**KIRKLEES METROPOLITAN COUNCIL
INVESTMENT & REGENERATION SERVICE**

Reference No: 2020/44/90682/W

Site Address: Croft Medical Centre, Cobcroft Road, Fartown,
Huddersfield, HD2 2RU

DECISION – DISCHARGE OF CONDITIONS 5 AND 6

Drawing:
Site Plan
Boundary Treatment

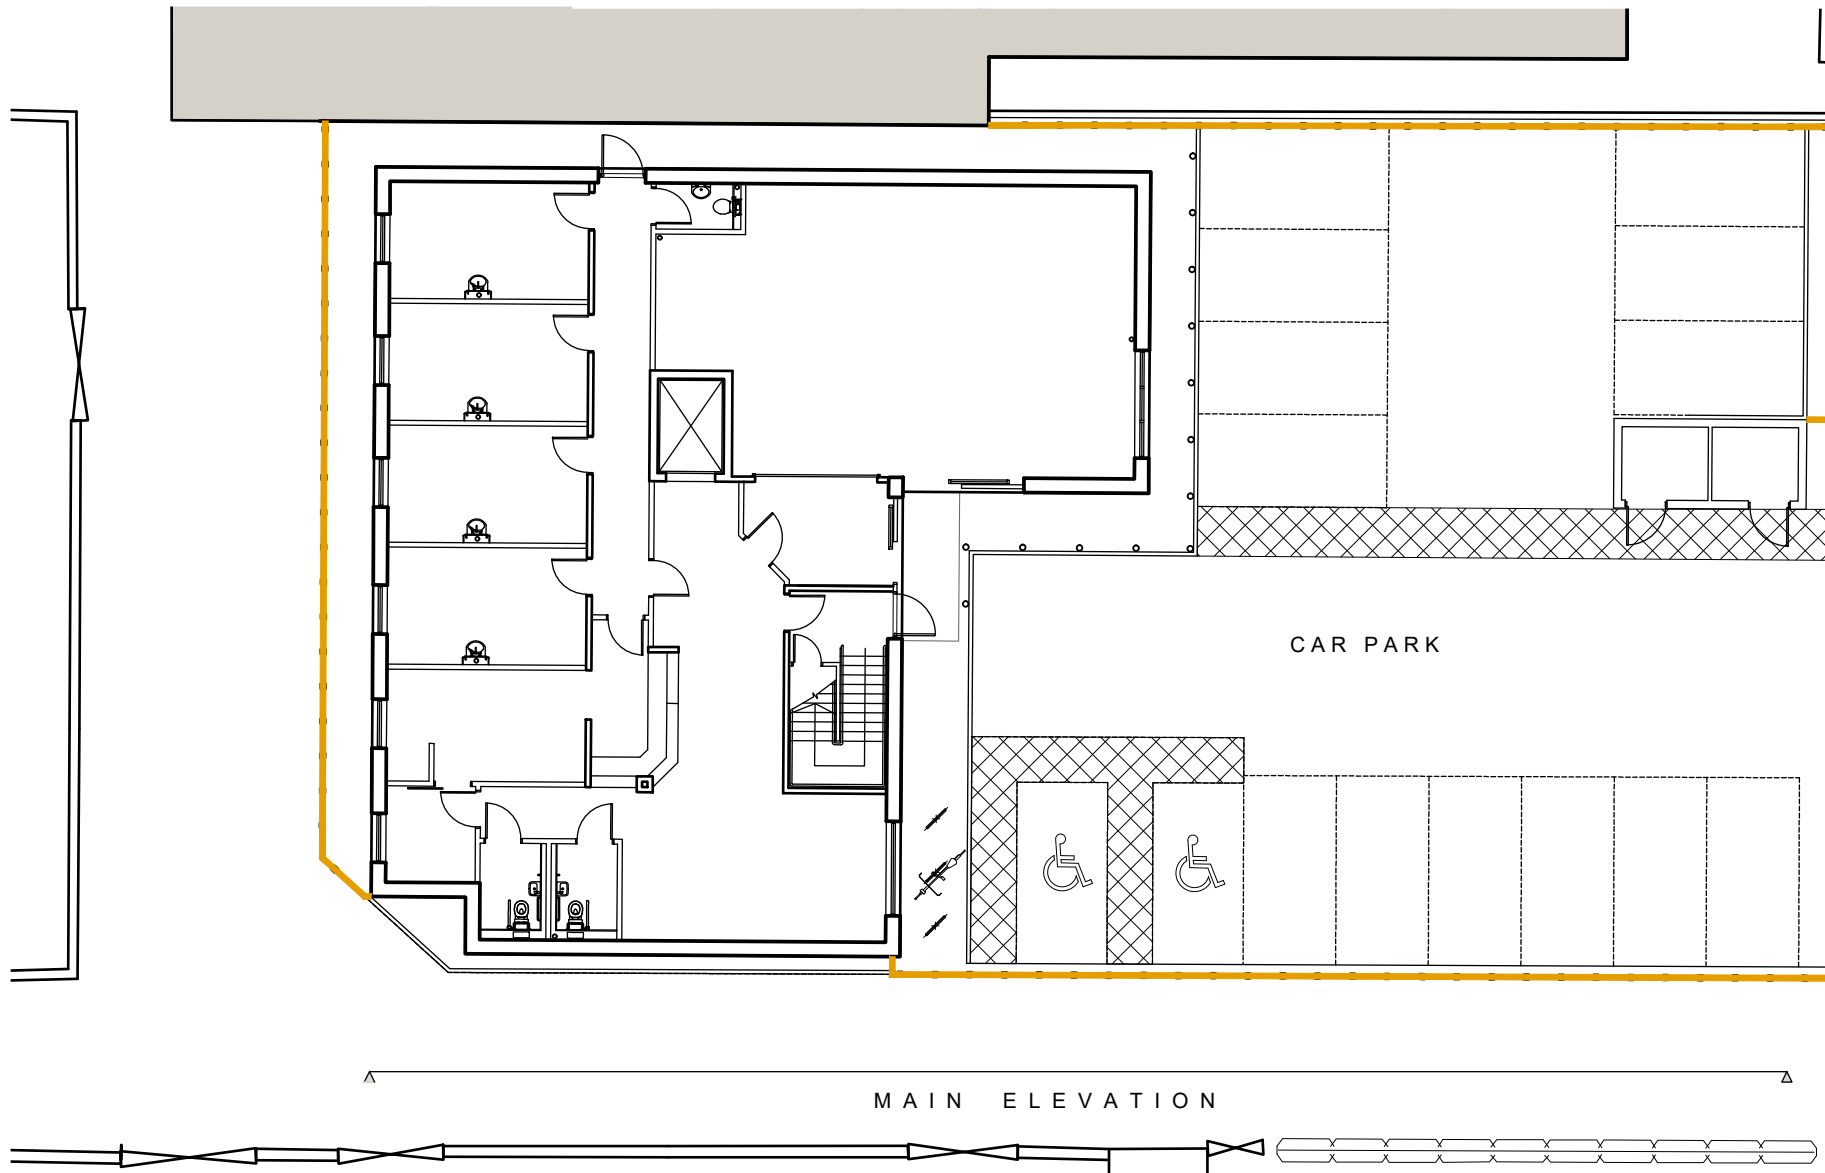
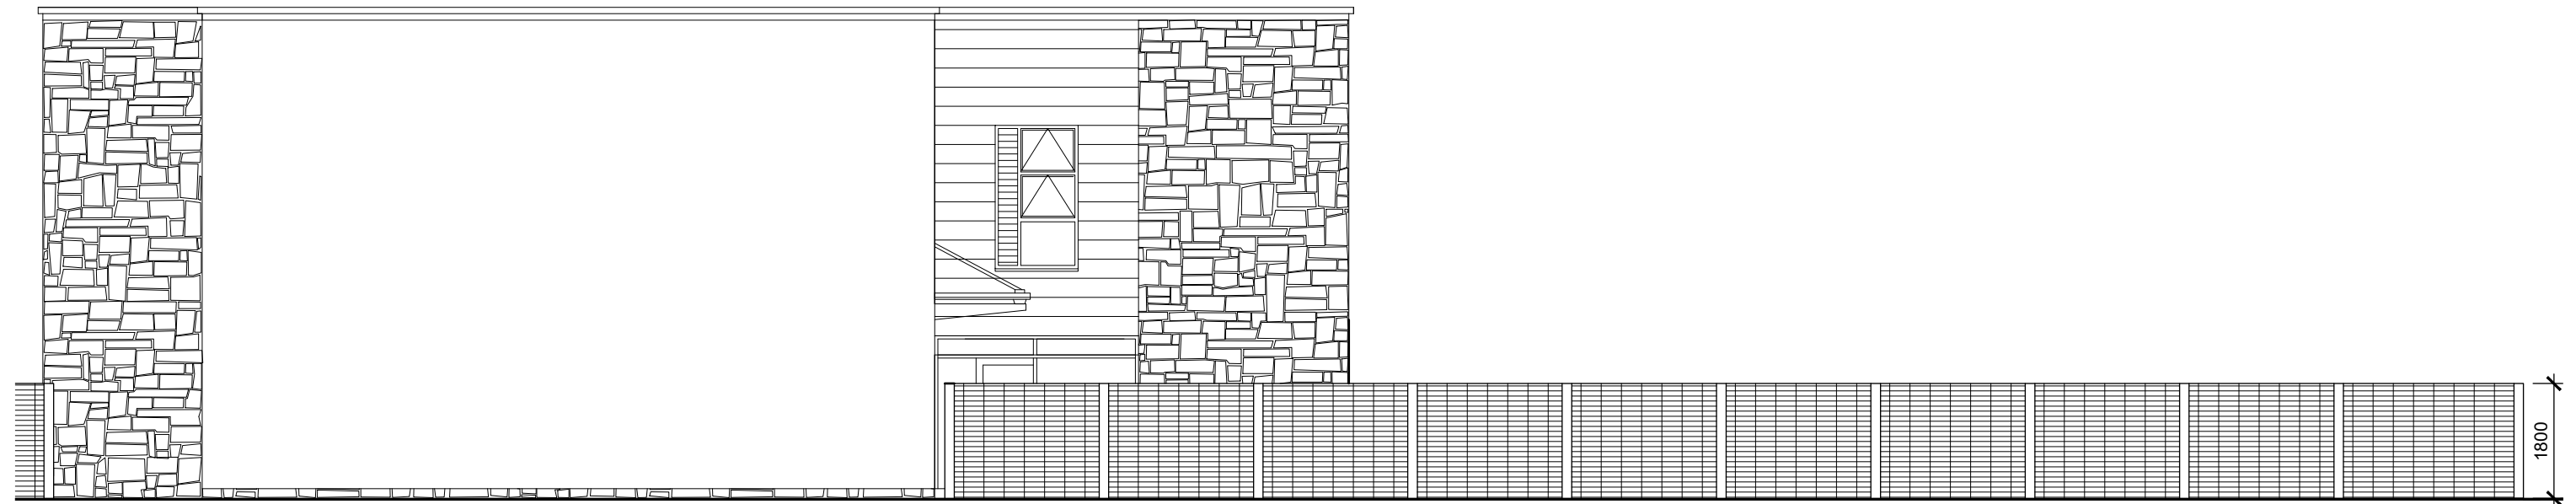
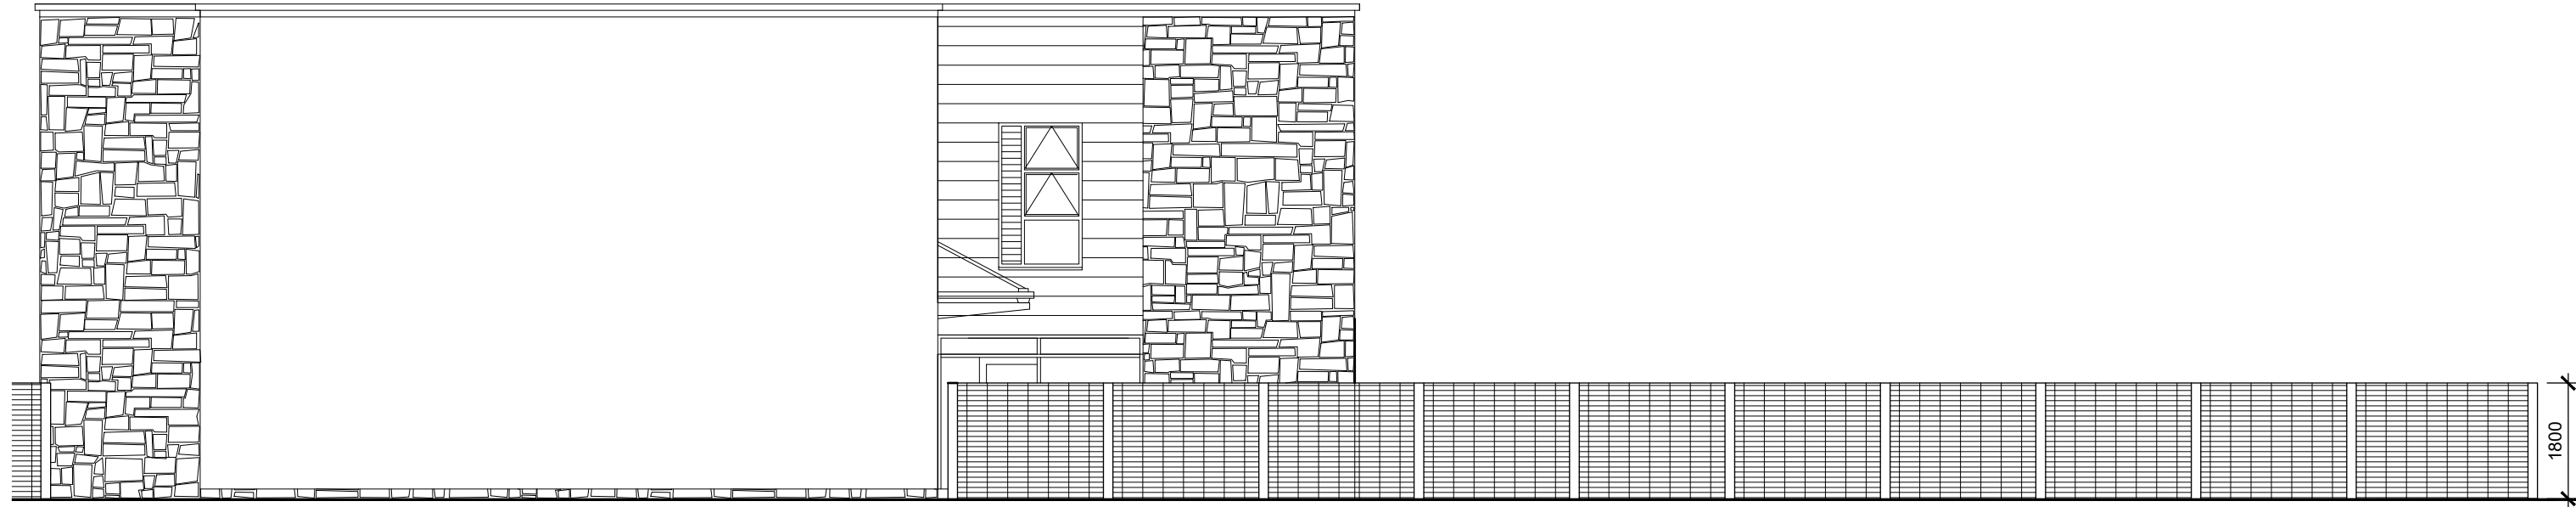
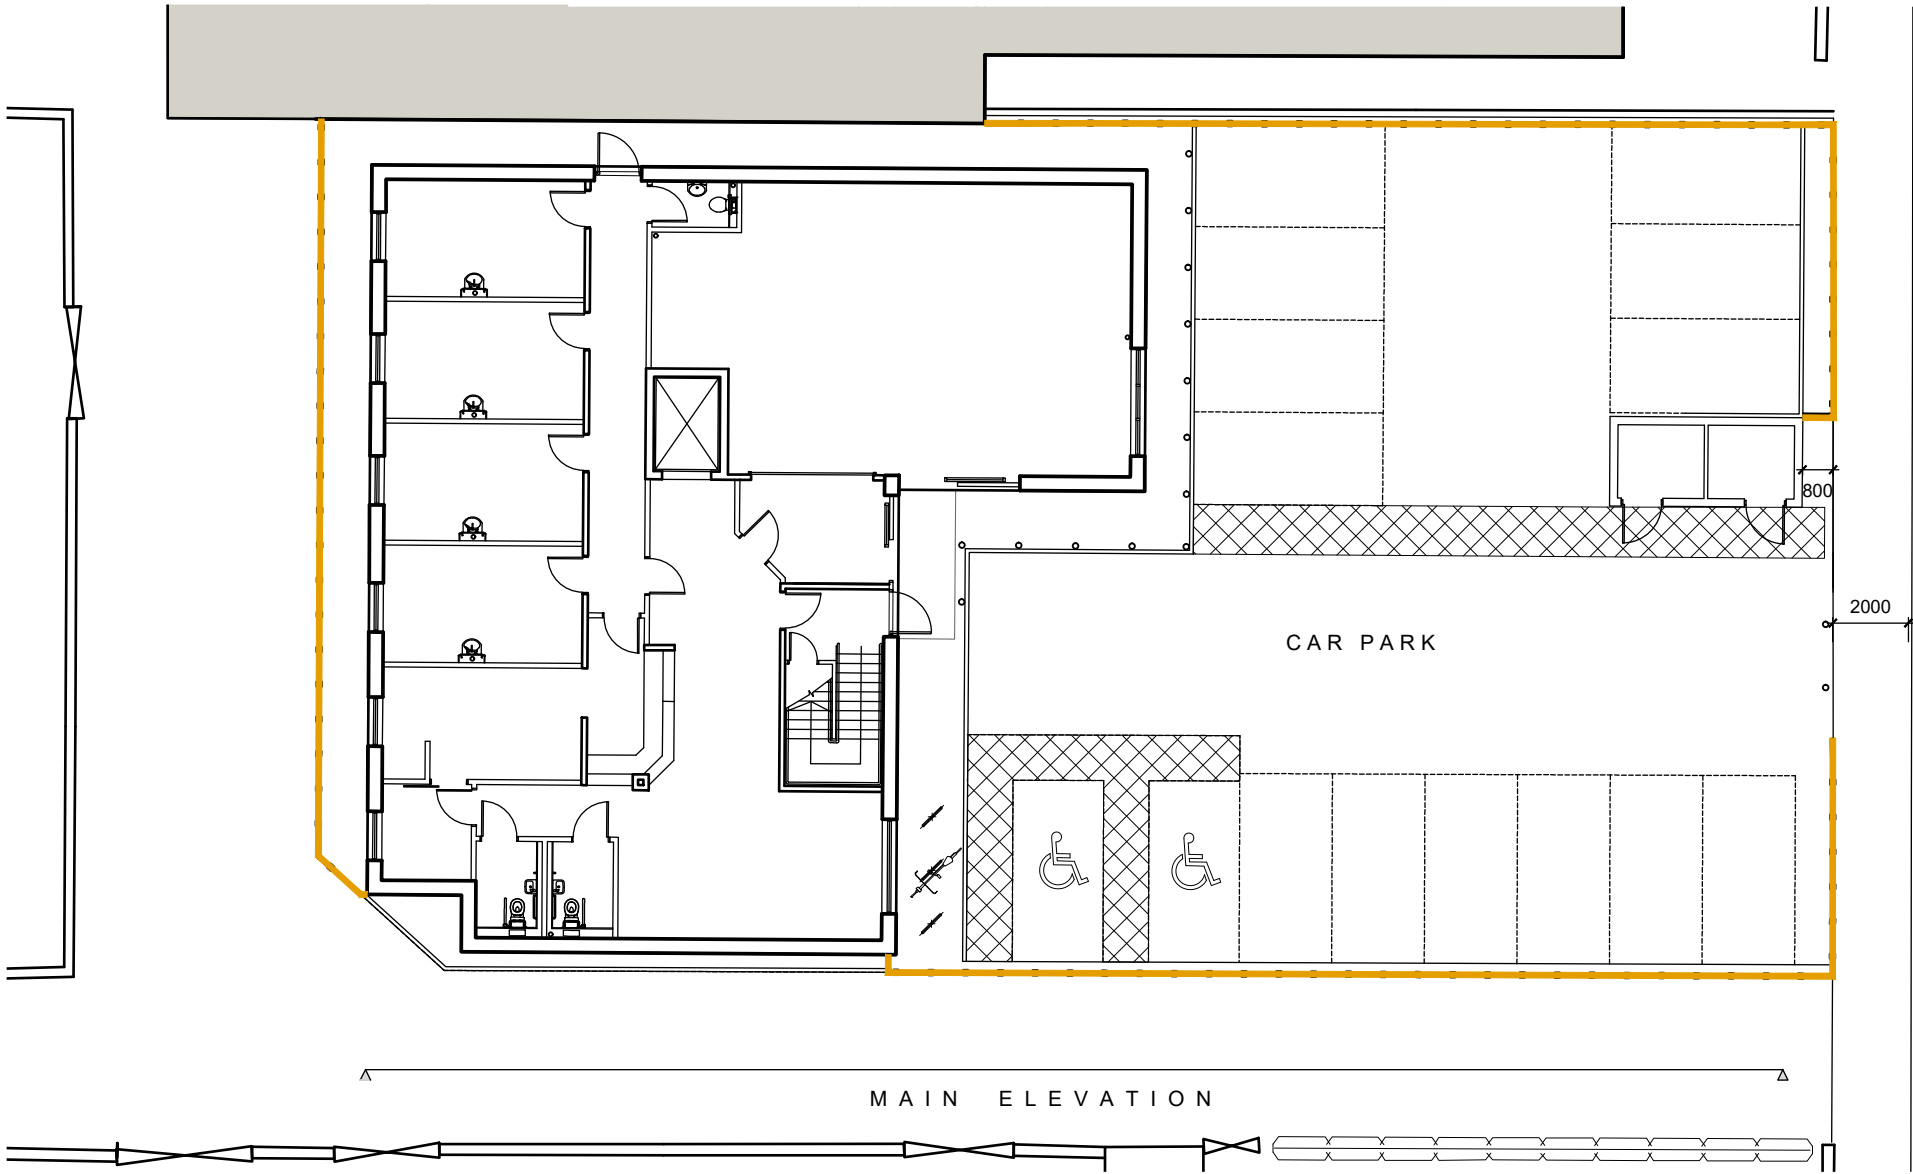
The submitted details have been reviewed by the Highways Officer who requires the fence to be reduced in height or set back 2 metres from the carriageway to protect sight lines at the entrance from Cobcroft Road. The applicant has confirmed that the fence has been set back in accordance with Highways' requirements.

These details show the fence set back 2 metres from the back edge of the carriageway edge of Cobcroft Road and are acceptable to discharge condition 6 subject to the completion and retention of the agreed details. In the interests of security a copy of the recommendations from the West Yorkshire Police Designing Out Crime Officer will be forwarded separately.
